Re - Stockton Sand Quarry Dredging Project, Fullerton Cove (SSD-9490) – Review of Environmental Impact Statement

BCD has reviewed the '*Stockton Sand Quarry Dredging State Significant Development – Environmental Impact Statement*' (EIS; prepared by Element Environment Pty Ltd and dated February 2020), including relevant appendices, annexures and attachments in relation to impacts on biodiversity, Aboriginal cultural heritage, flooding and coastal processes. NSW National Parks and Wildlife Service (NPWS), who are also part of the Environment, Energy and Science Group, have reviewed the above document in relation impacts on National Parks conservation estate.

Stockton Sand Quarry Dredging Project, Fullerton Cove (SSD-9490) – Review of Environmental Impact Statement

Drawn by: GIS_user File: T:\Spatial\Working\3706 Stockton\Figure_4_Survey effort.mxd Last updated: 7/16/2019 11:00:36 PM

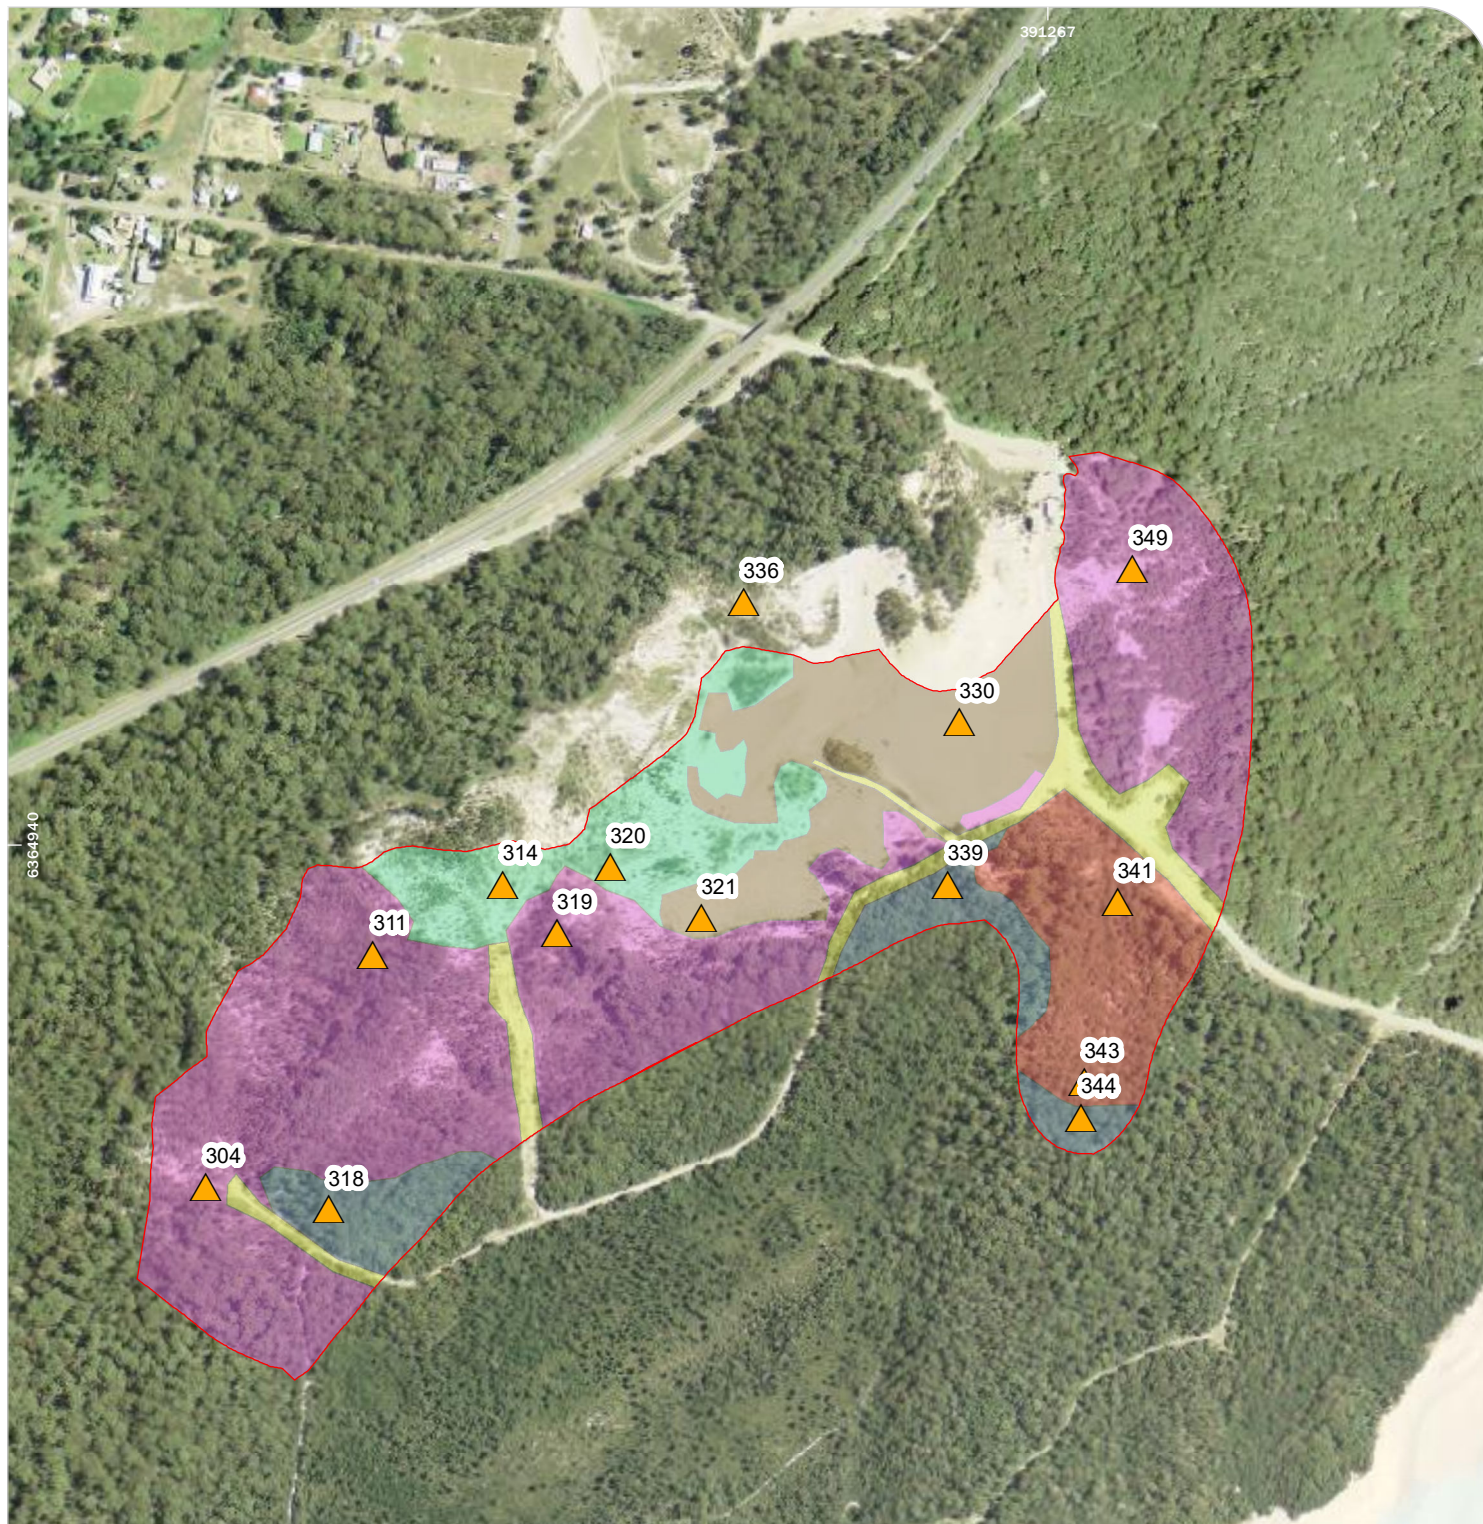
BCD requires (as per the '*NSW Guide to Surveying Threatened Plants*' (OEH 2016)) spaced parallel transects for all threatened flora species across all suitable habitat based on a species growth habit to determine suitable spacing widths for detectability. Additionally, Figure 4 (Survey Effort) clearly shows that the 'Orchid Survey' (i.e. targeted threatened orchid survey) comprised of limited meanders that did not cover all the suitable habitat.

The BAM requires targeted surveys (not opportunistic searches) to be undertaken for all candidate flora species across all suitable habitat, unless the species is assumed present or an expert report is provided. These surveys are to be conducted when a species is detectable, such as flowering or fruiting, given that flowering material or fruits are often required for positive identification. Any variation in the survey methodology or timing from that identified by the Threatened Biodiversity Data Collection (TBDC) or the '*NSW Guide to Surveying Threatened Plants*' (OEH 2016) should be justified in the BDAR. The TBDC should also be consulted to see if there are any species-specific requirements, such as use flowers for identification, use a reference population, or apply geographic constraints etc... The BDAR must detail how each candidate threatened flora species was surveyed, including details on (but not limited to):

Targeted surveys should be undertaken for candidate flora species in accordance with OEH '*NSW Guide to Surveying Threatened Plants*' (OEH 2016) and the Threatened Biodiversity Data Collection across all suitable habitat and at their appropriate seasonal survey times. If surveys are not undertaken, an expert report should be prepared in accordance with Section 6.5.2 of the BAM guidelines (OEH 2017) or the species should be assumed to be present.
